Head of Planning
The Arun Civic Centre
Maltraves Road
Littlehampton.
West sussex
BN17 5LF

14th August 2017

Planning Application BR/194/17/PL

DRAWING
Proposed Elevations North-South

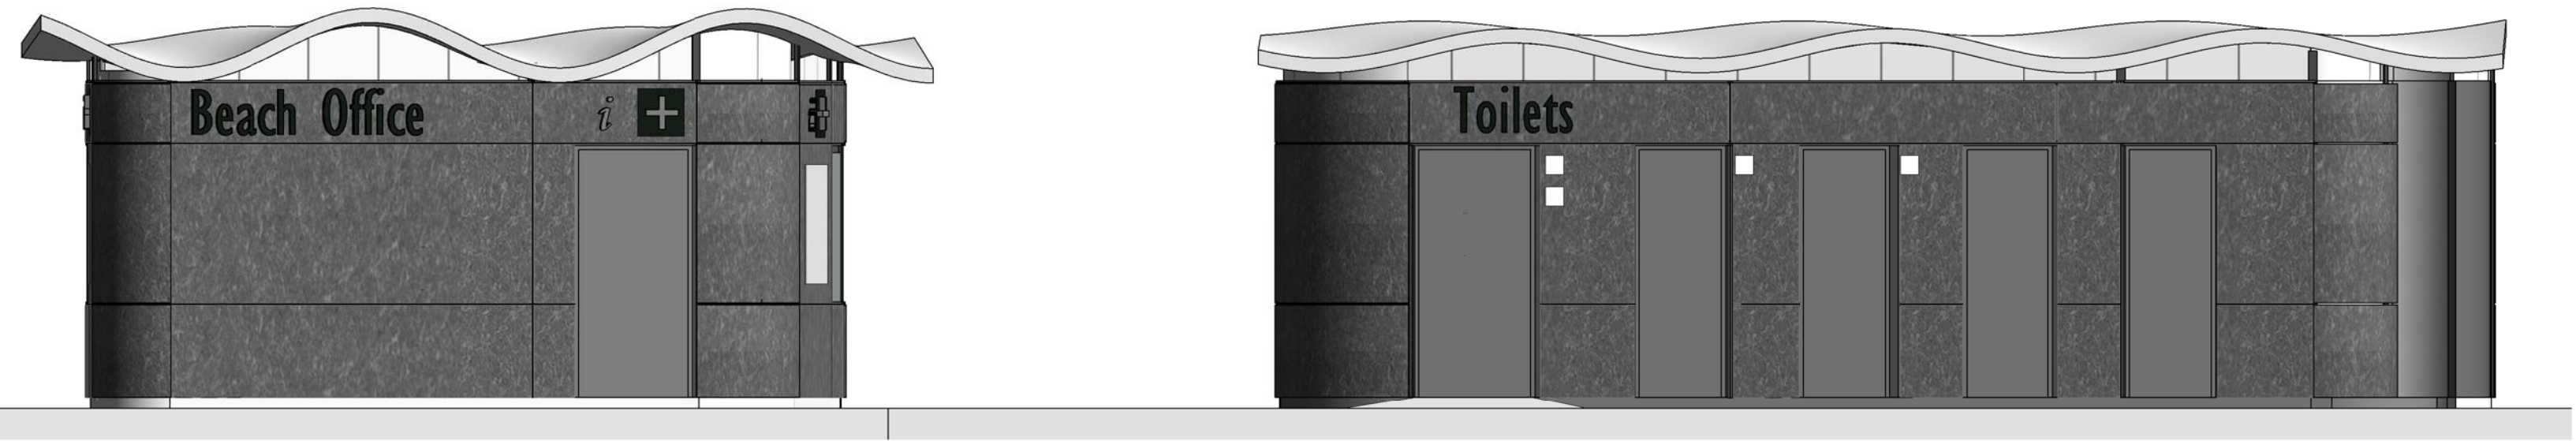
As the decision has undoubtedly already been made by yourselves I would like to suggest the following details should be considered. The proposed new plans clearly have a smaller footprint than the existing Foreshore Office eg: new facility approximately 3.4m current building 4.4m therefore ,doors facing South with 1/2m windbreaks, which could be used as notice boards and offer protection from the elements by users would still produce an extra saving on the width of the promenade.

It makes no sense at all for the toilets to face the road when they are primarily required for promenade users. They do not need to be advertised to passing motorists. Pedestrians on the road side will find facilities only a few hundred yards further along at the Regis Centre!! Which, in my opinion is where toilet facilities should be upgraded and enlarged to facilitate all visitors not just promenade users.

DRAWING
Proposed Toilet Elevations

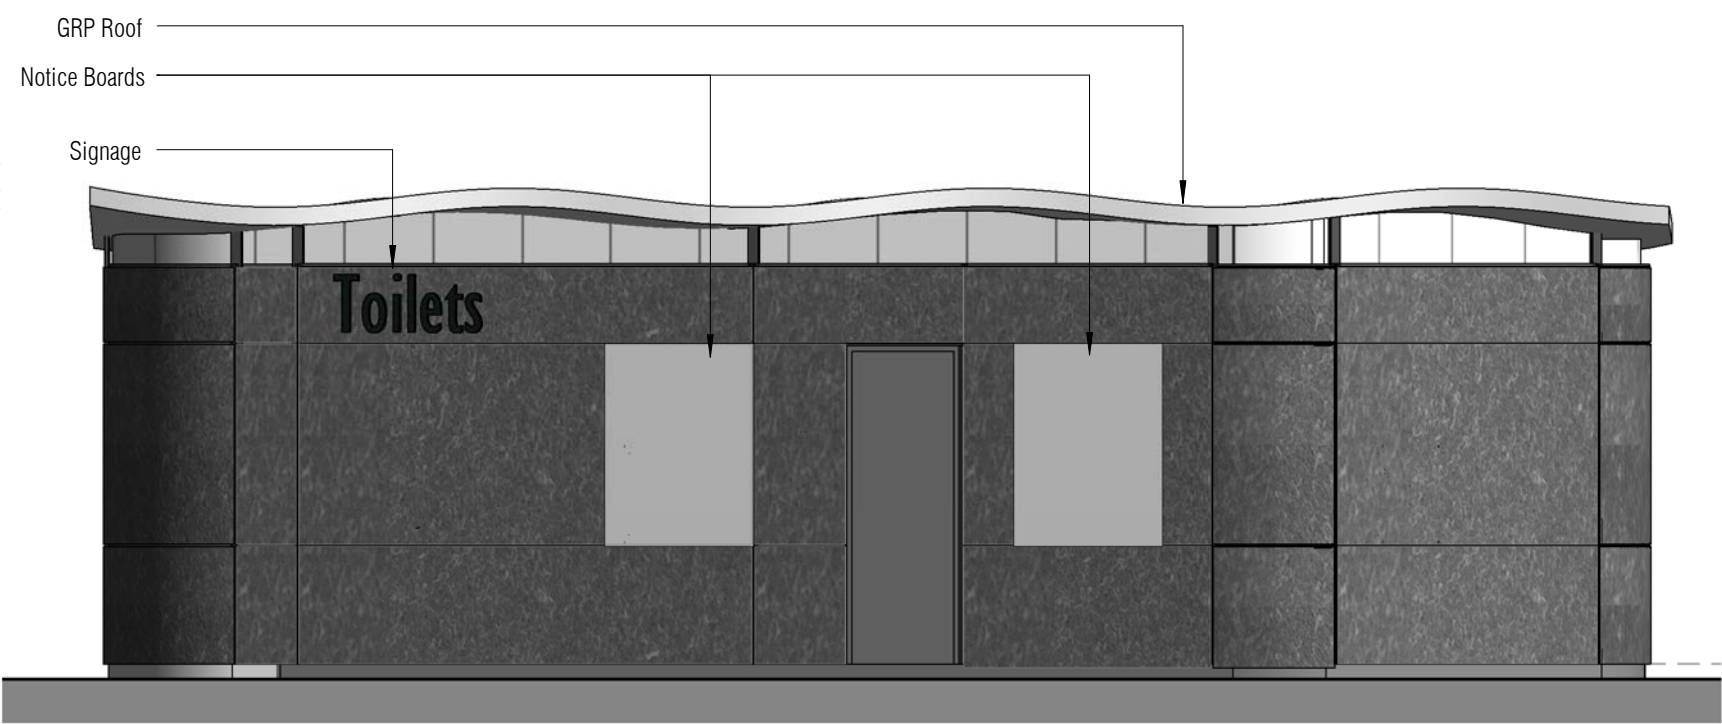
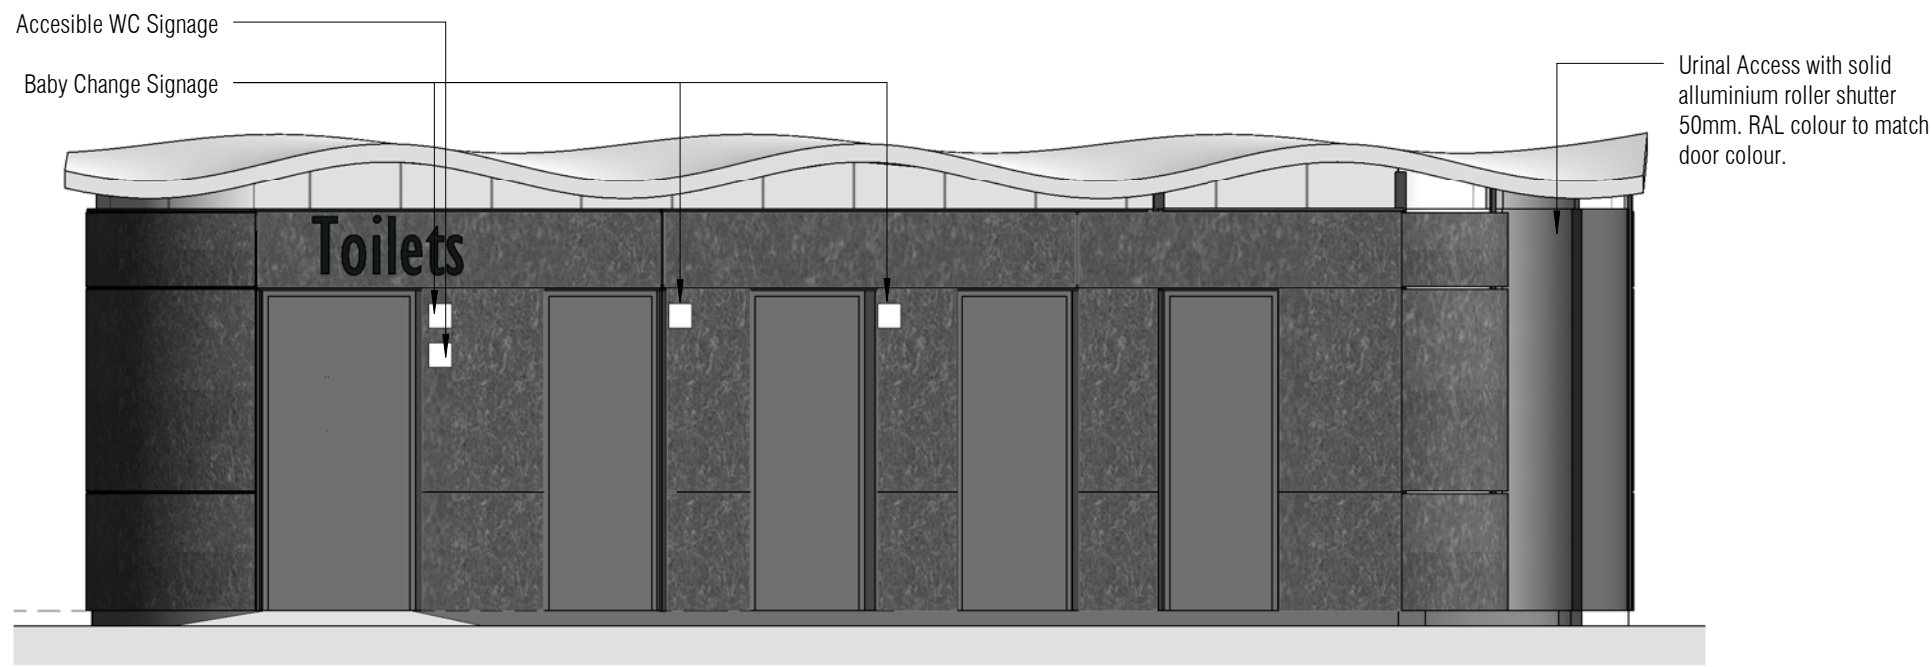
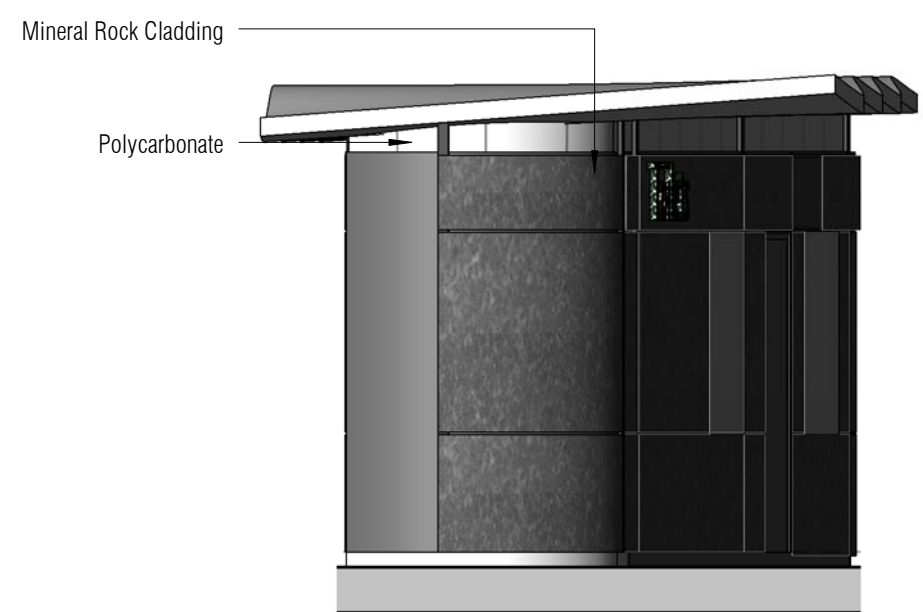
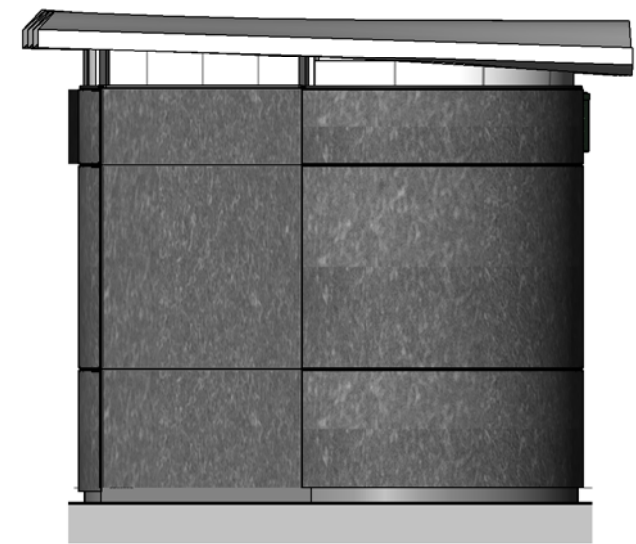
Also, the width of the proposed new building could also be reduced further by slight alteration of the proposed disabled facility.
